Ribble Valley Borough Council
Housing & Development Control

Application no: **3/2021/0406**

Address: **Deli Solutions Ltd Lincoln Way Clitheroe BB7 1QD**

Proposal: **Discharge of Condition 5 (Construction Method Statement) of planning application 3/2018/0984.**

Drawn By	A.Wagjiani
Drawing No.	PMTD100262
Approved By	TBC
Date Drawn	25/08/2020

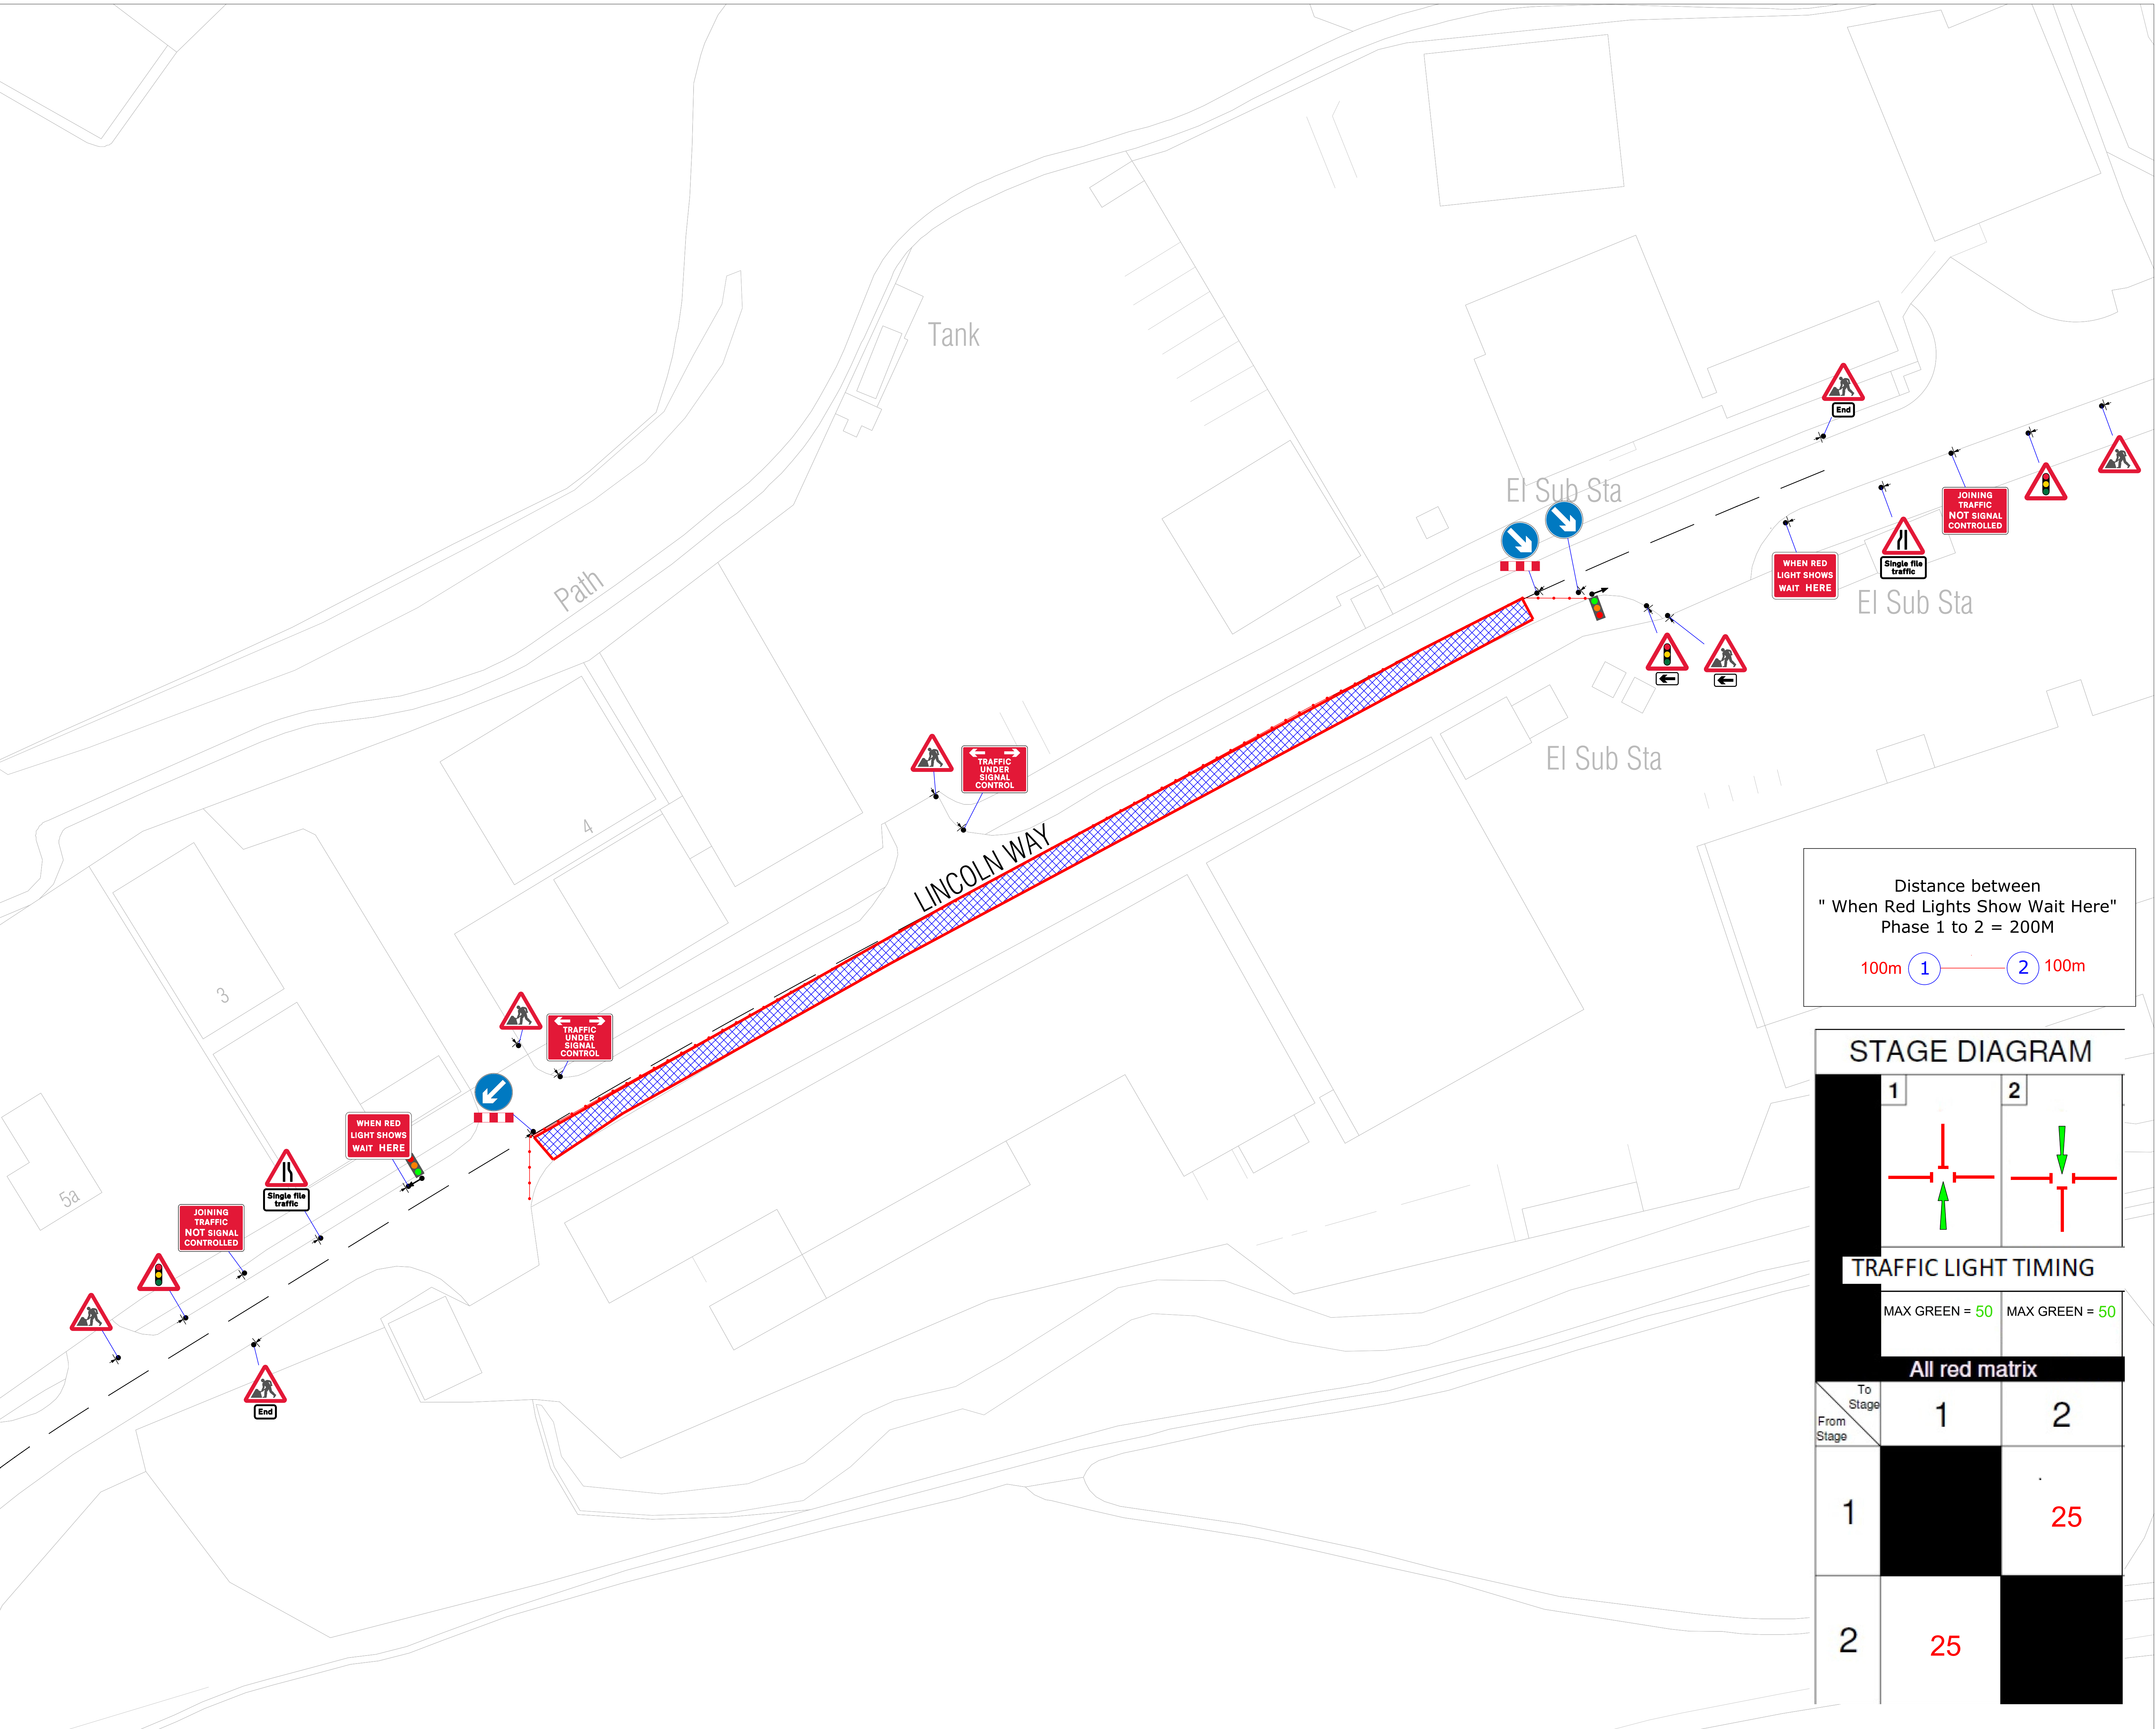
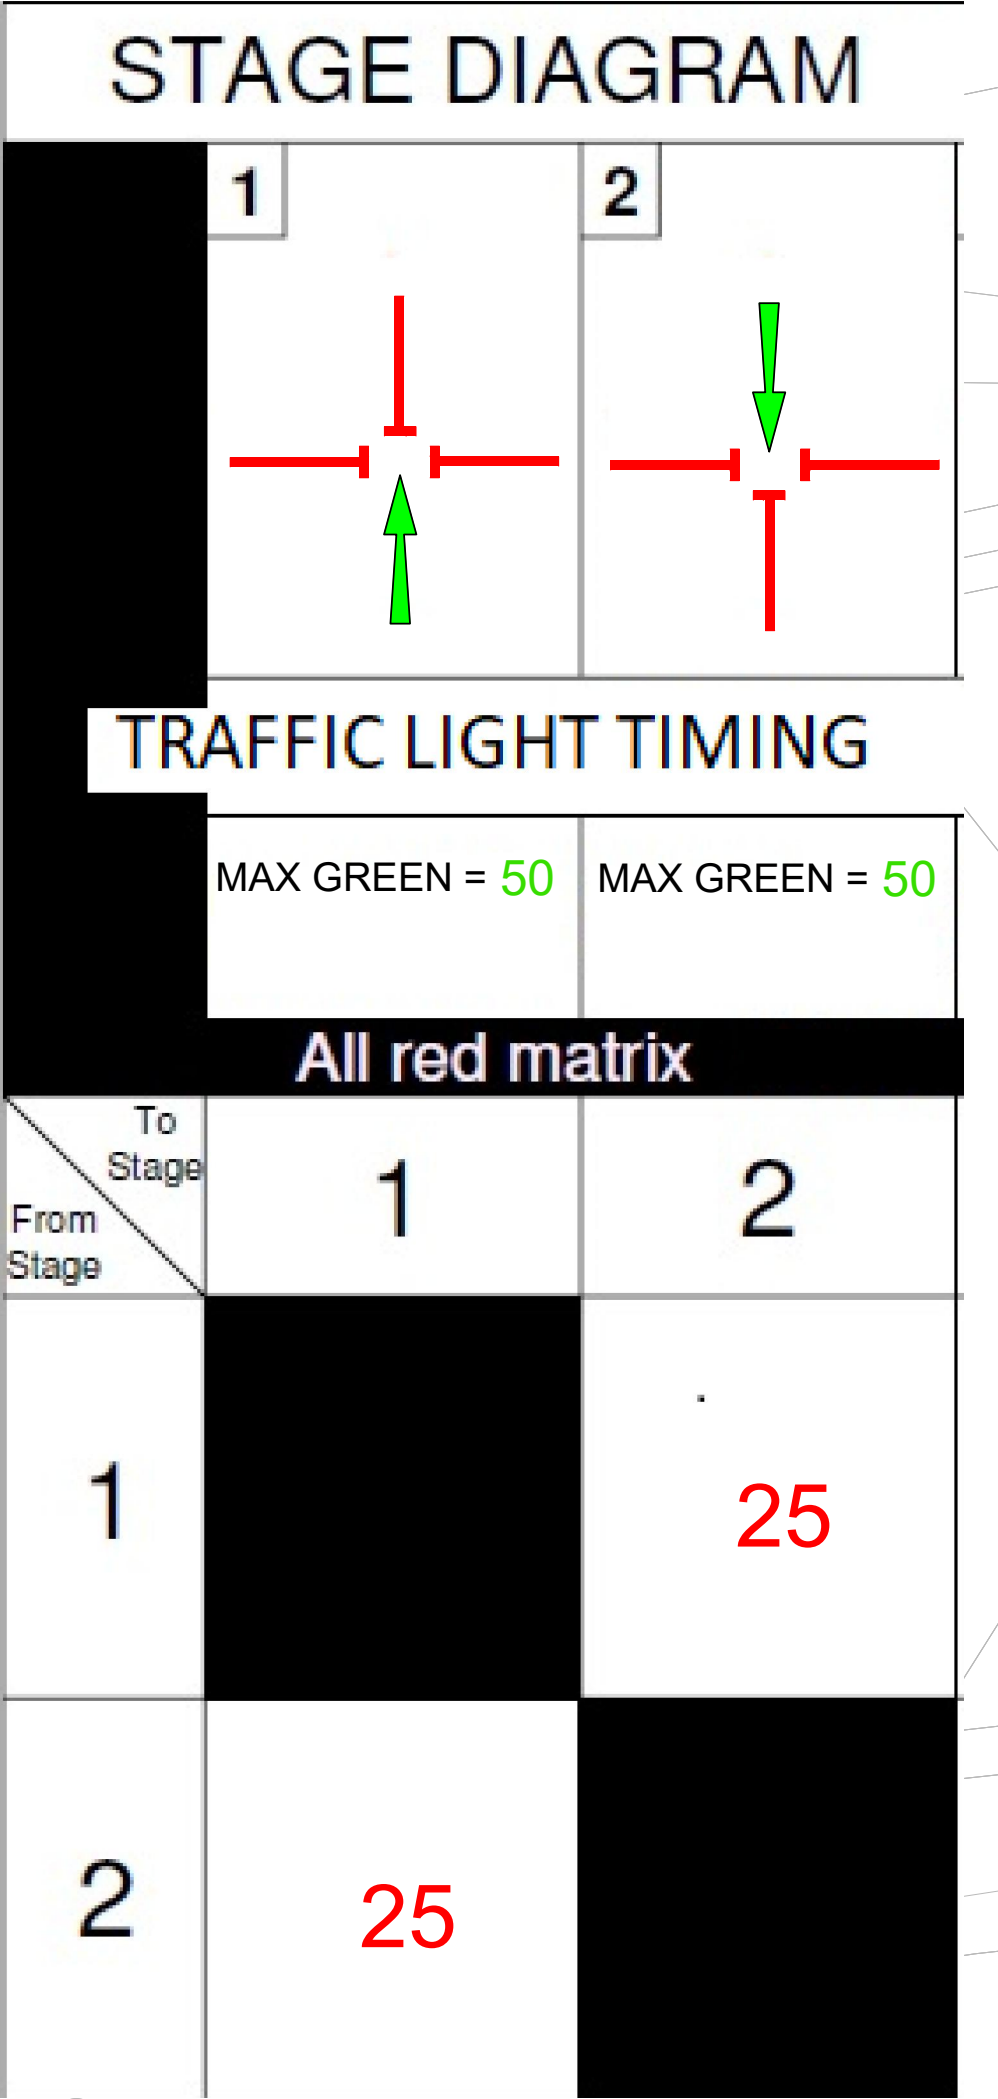
The LHA have reviewed PRIMUS drawing number PMTD100262 titled "Traffic Management Plan" and understands that during the construction of the site, one lane of Lincoln Way will be closed and replaced with two-way temporary traffic lights due to work being undertaken adjacent to the highway.

The LHA have no objection for the use of the two-way temporary lights and the traffic signs which will be used to warn vehicles of the highway works along the road.

Therefore, there is no objection to the Discharge of Condition 5.
